**EL PASO COUNTY PLANNING & COMMUNITY DEVELOPMENT
SIGN APPLICATION**

Name: Aspen View Homes
 Address: 555 Middle Creek
Pkwy, Ste 380
CO Springs, CO 80921
 Zone: _____
 Legal Description: _____

CLIENT: ASPEN VIEW HOMES
FILE NAME: TG 4X8 (MARKSHEFFEL & MESA RIDGE)
DESIGNER: MICHAEL M.

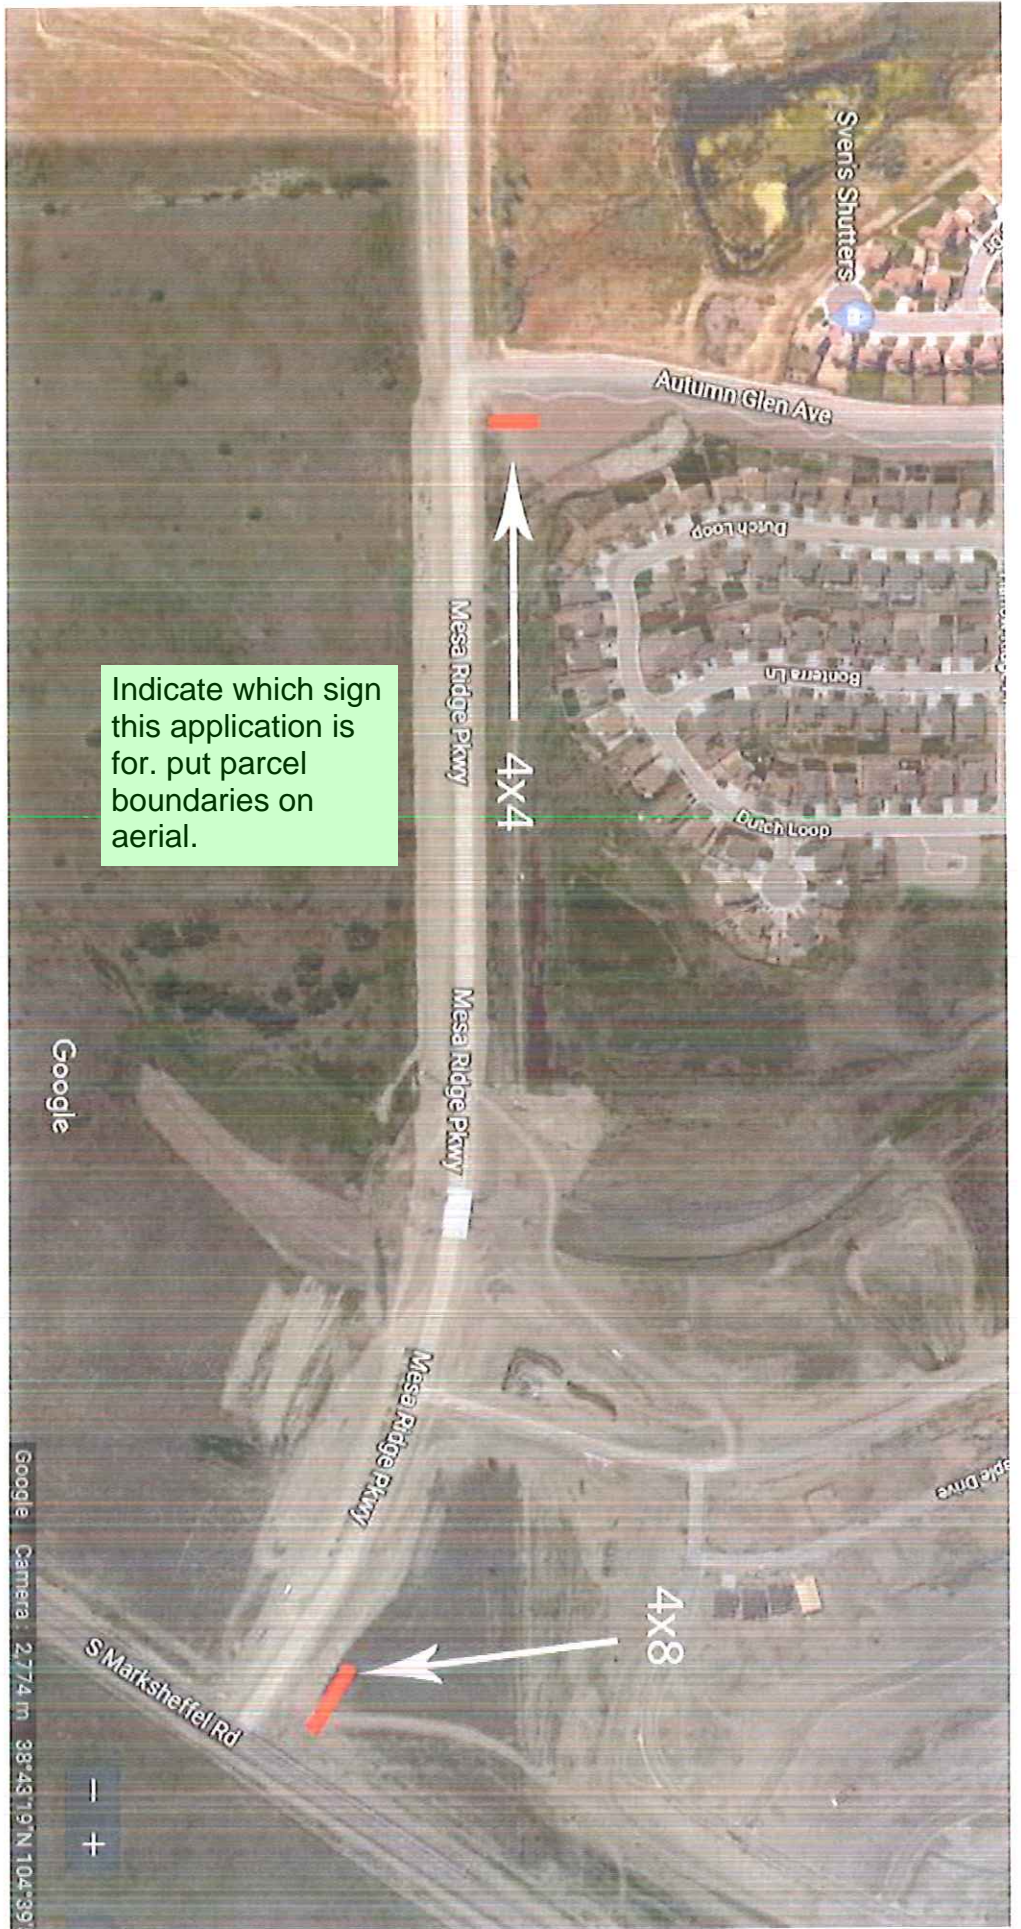
Incorrect schedule number

Fill this out - 32 sf
